RFI

To: Jordan & Skala Engineers, Inc. RFI #: 65
14240 Midway Road, Suite 350 Date: 2/23/2012
Dallas, TX 75244 Job: EB-02 Keller Springs Lofts
Ph: 469/385-1616 Fax: 469/385-1615 Phone: 877-777-5115

Subject: revised scale to coordinate with Architectural and Plumbing sheets

FIRE PUMP ROOM PLAN VIEW
SCALE: NTS

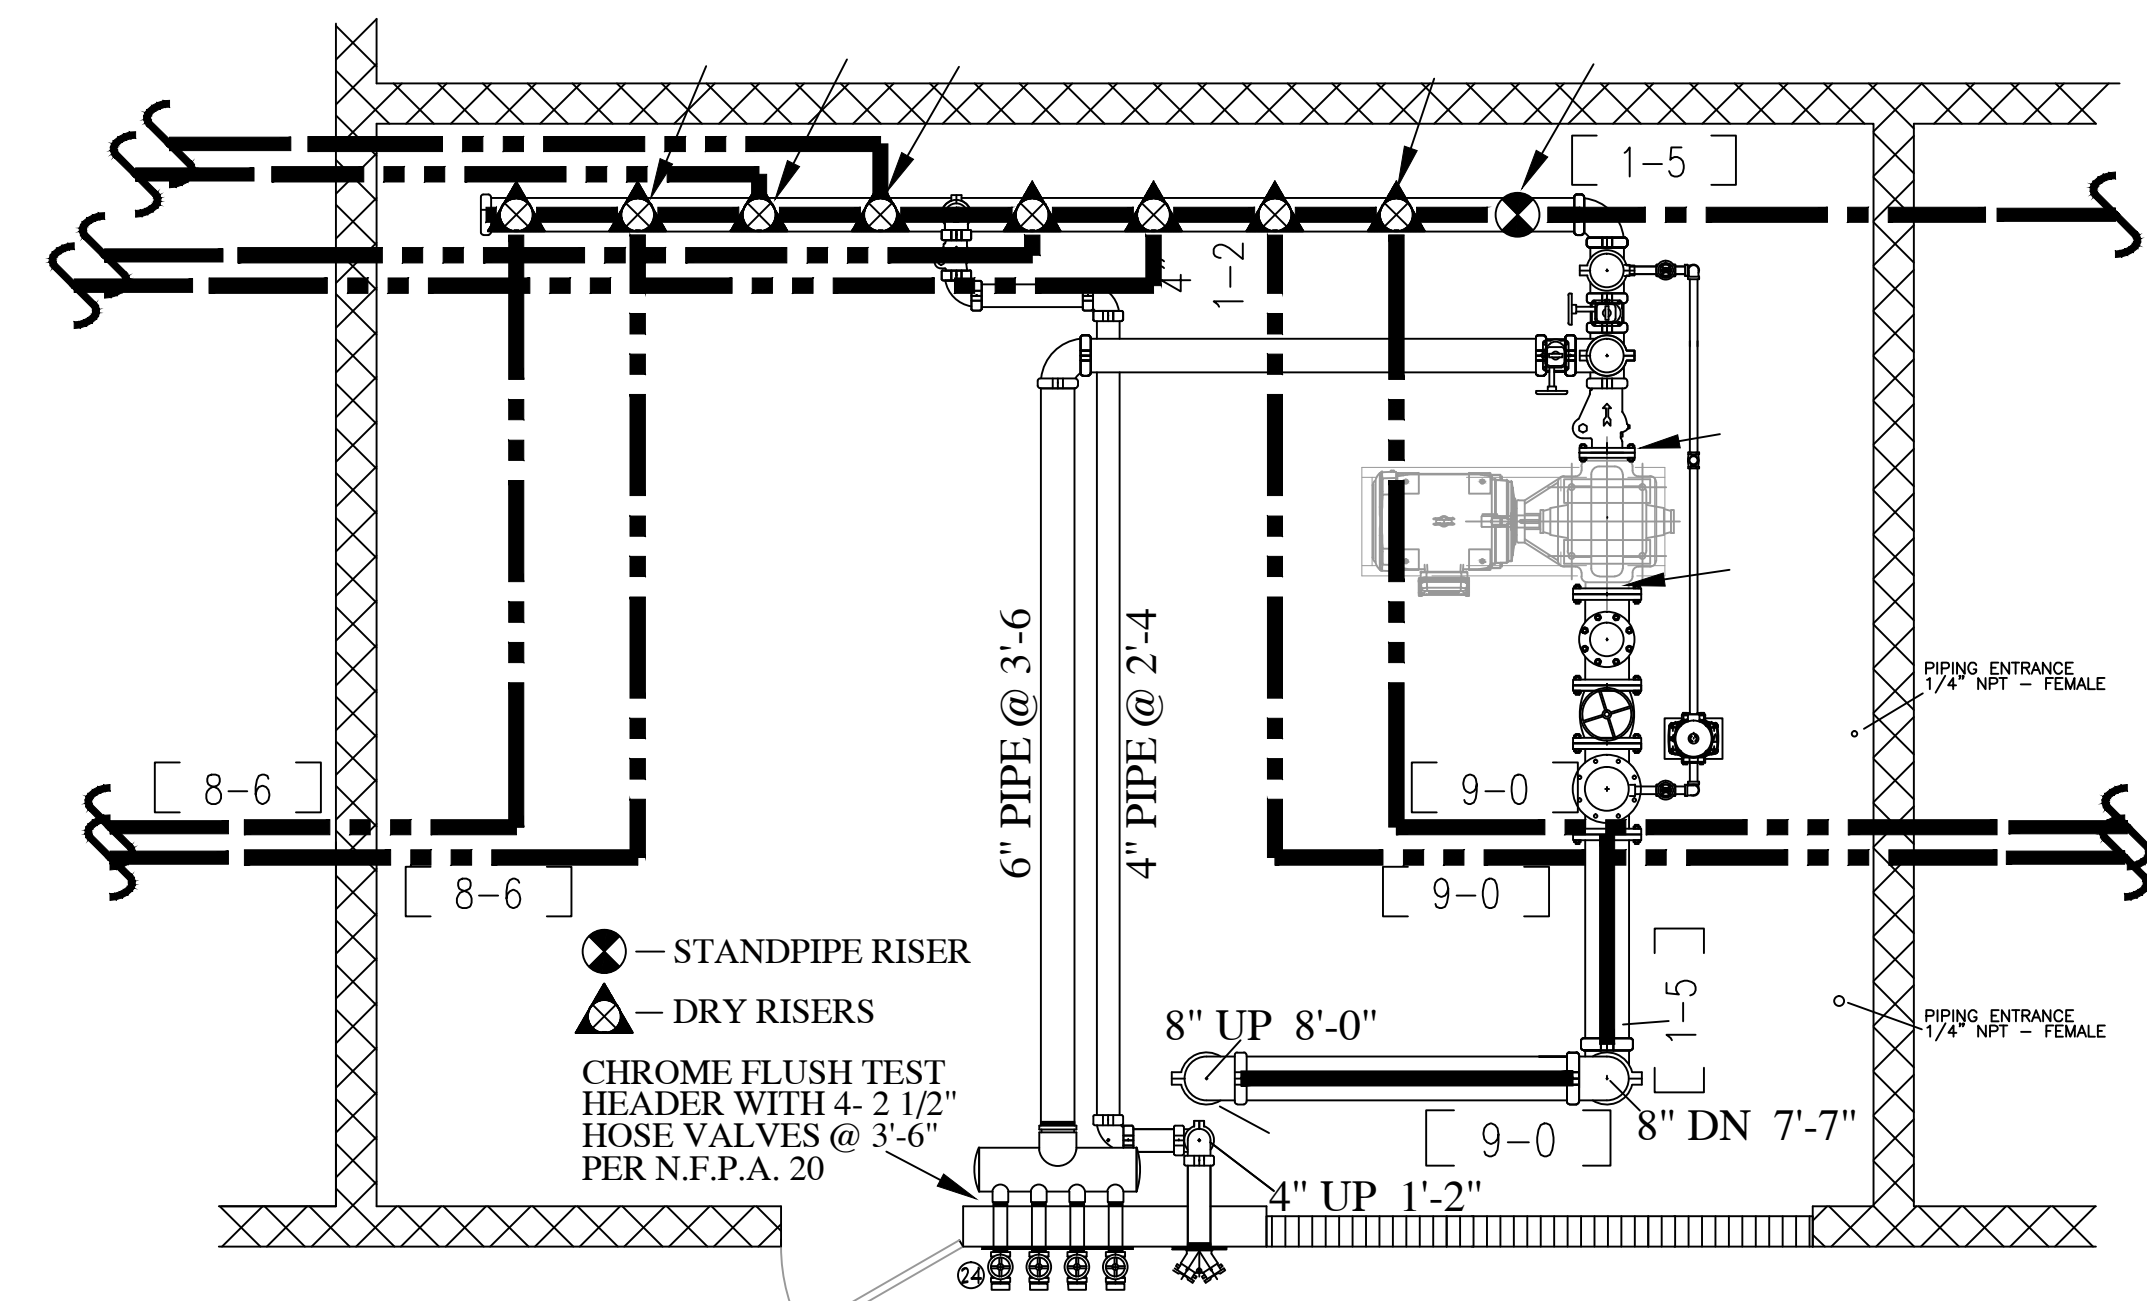
Request: Architectural 4/6.4 show inside dimensions for the Pump Room as 24'-6" X 17'-10", sheet 3.1D and P3.1D scale out the same using the 1/8" scale. Going to P-9.1 (which my plumber did) and using the 1/4" scale that is called out, the room scales to 21'-0" X 15'-6". The detail and sheet needs to be revised to scale to the correct dimensions which are 24'-6" X 17'-10" this error has already created problems with my plumber who had to move his plumbing underground after using the detail on P-9.1. **Date Required:** 3/1/2012

Response:
See attached sheet P-9.1 for corrected plan scale.
